4 August 2011

**Re: Review of Major Project Application MP10_0027
Site 3 (Stages 2 & 3) - 1 Australia Avenue, Sydney Olympic Park**

Figure C.2 Summer solstice shadow studies

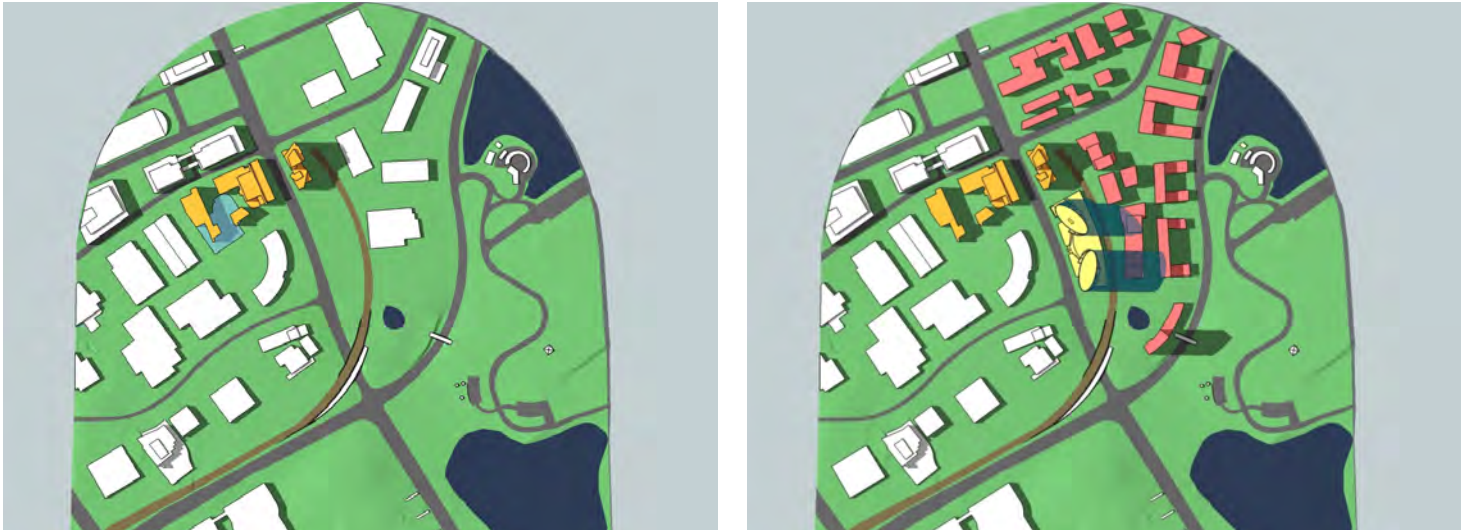
The assessment of solar access and overshadowing contained in the Environmental Assessment report and the accompanying Solar Access Analysis report primarily focus on the residential amenity of the proposed development and does not adequately address overshadowing impacts to surrounding developments. The documents submitted as part of the application do not include shadow diagrams showing solar access to the site and adjacent properties.

The site of 1 Figtree Drive is particularly vulnerable to overshadowing impacts as it is located directly southwest of the proposed towers. However, shadow diagrams demonstrating the overshadowing impacts of the development to 1 Figtree Drive have not been provided, nor has a detailed assessment of the number of hours of direct solar access that 1 Figtree Drive will achieve as a result of the development.

Further assessment of solar access and overshadowing impacts is required and should take into consideration impacts on the existing and potential future building envelopes of 1 Figtree Drive, as specified in Sydney Olympic Park Master Plan 2030.
